Recommendation Report for Lawful Development Certificate for a Proposed Use or Development

REF NO: AL/90/19/CLP

LOCATION: St Helier
Hook Lane
Aldingbourne
PO20 3TE

PROPOSAL: Lawful development certificate for a proposed conversion of free standing garage in to sleeping accomodation.

PROPOSED PLAN AND ELEVATION

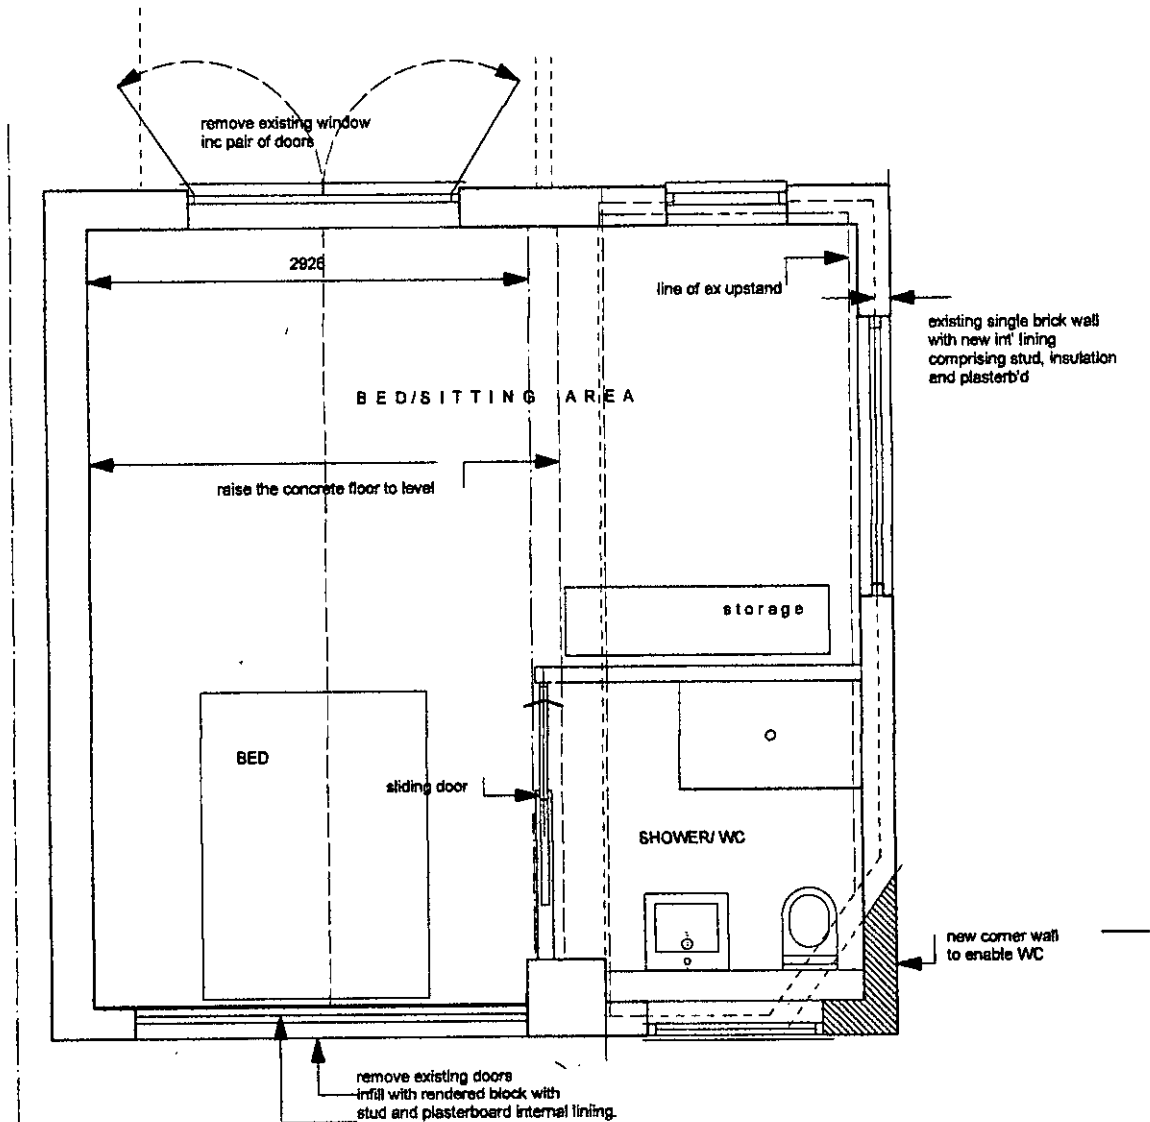
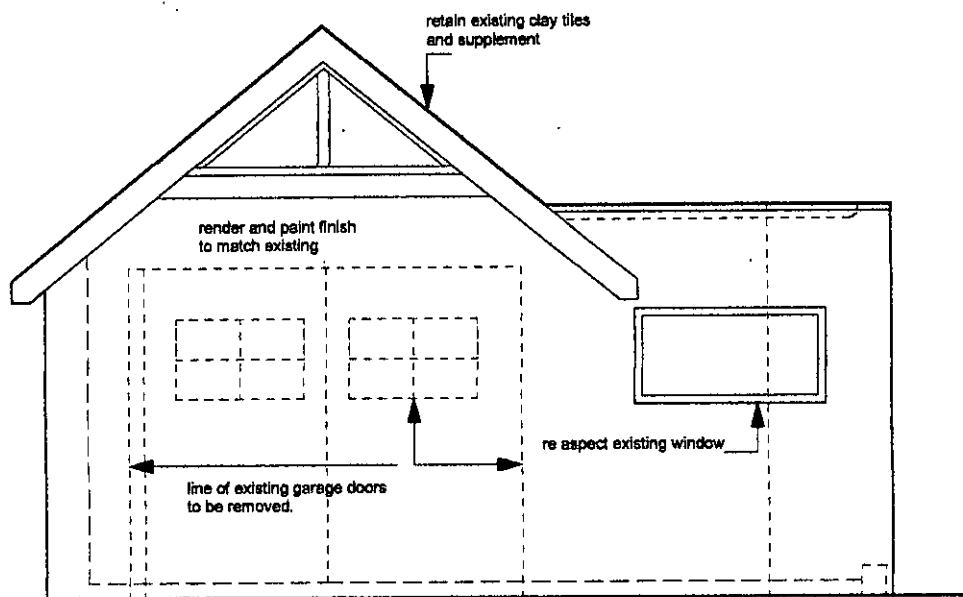
The proposed conversion is considered to conflict with Class E(a) of the Town and Country Planning (General Permitted Development) (England) Order 2015 as the use would not be 'incidental' and fails to meet the requirements of this class.

- The proposed development conflicts with Schedule 2, Part 1, Class E (a) of the Town and Country (General Permitted Development) (England) Order 2015. The conversion is not for a use incidental to that of the dwellinghouse.
